Application by SP Manweb for Reinforcement to the North Shropshire Electricity Distribution Network
The Examining Authority's written questions and requests for information (ExQ1)
Issued on 27 March 2019

Scale: 1:2,500@A1	Date: October 2018	
Drawing No: Sheet 0 of 16	Revision: v5.0	
Approved By: ECU	Checked By: NTR	Drawn By: ANI

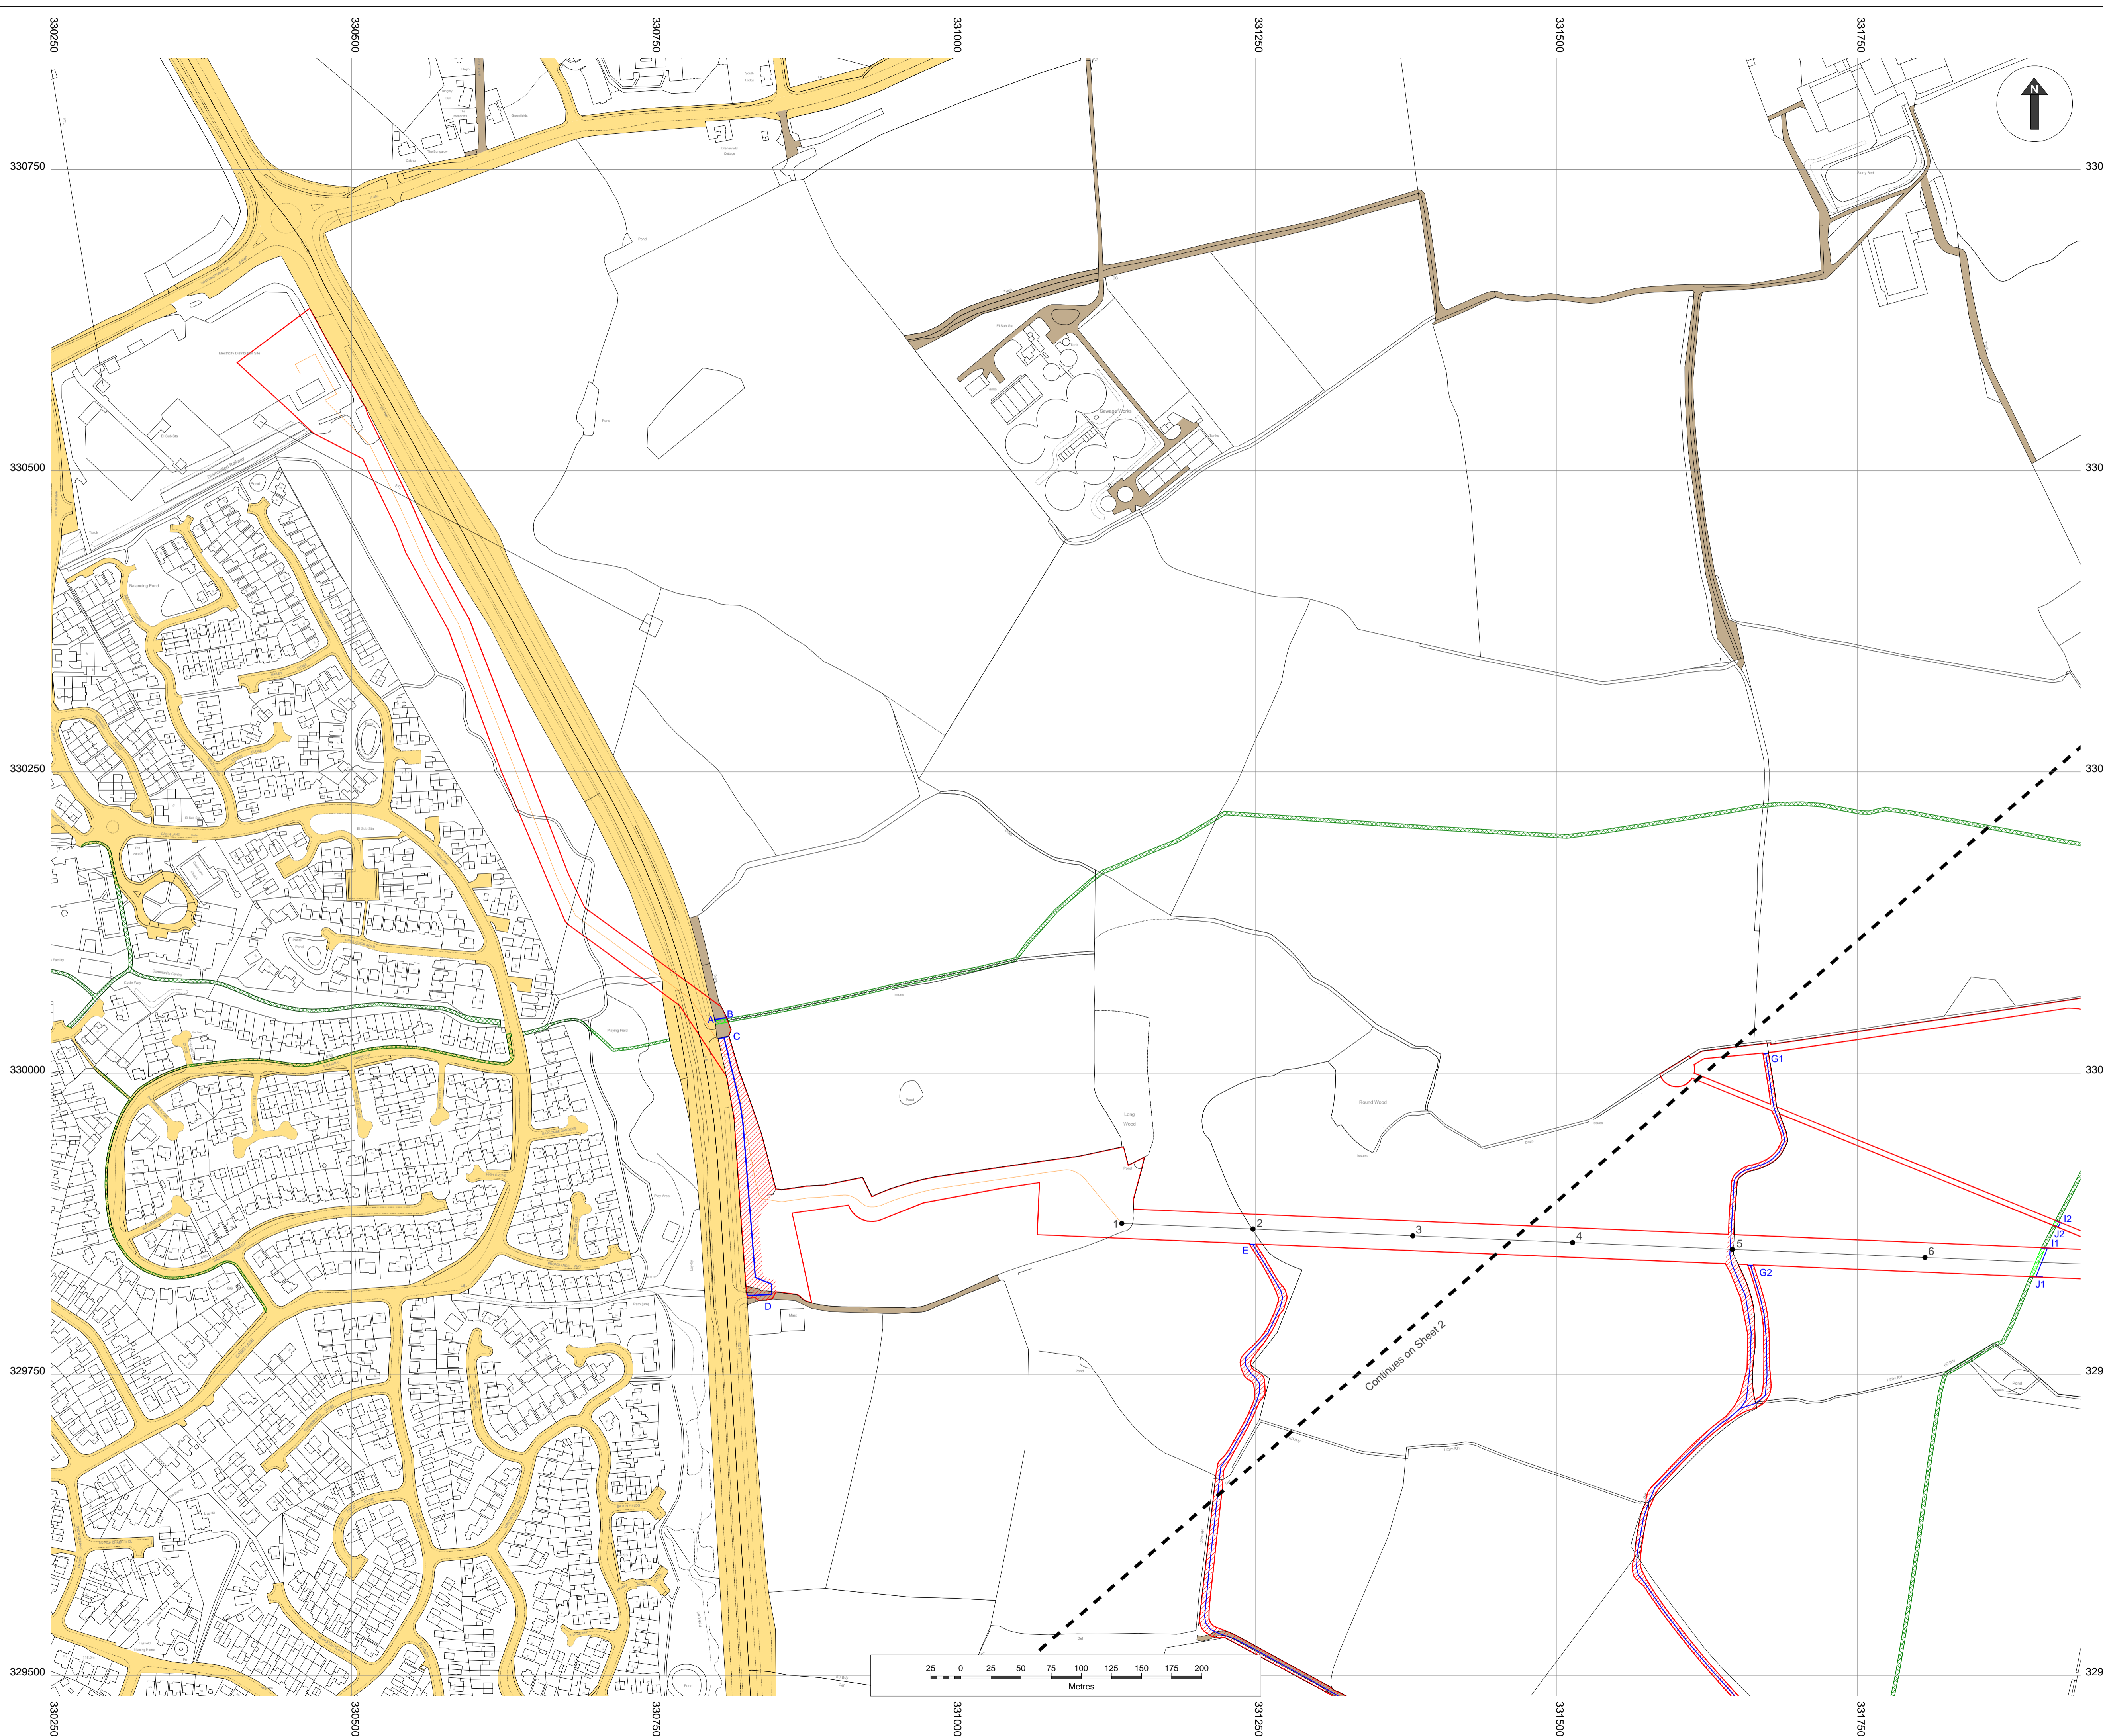
Q7.0.6	The Applicant	<p>Access and Rights of Way Plans</p> <p>What is the difference between private road/ access (shown in brown) and privately maintained access (shown in red hatching)?</p>
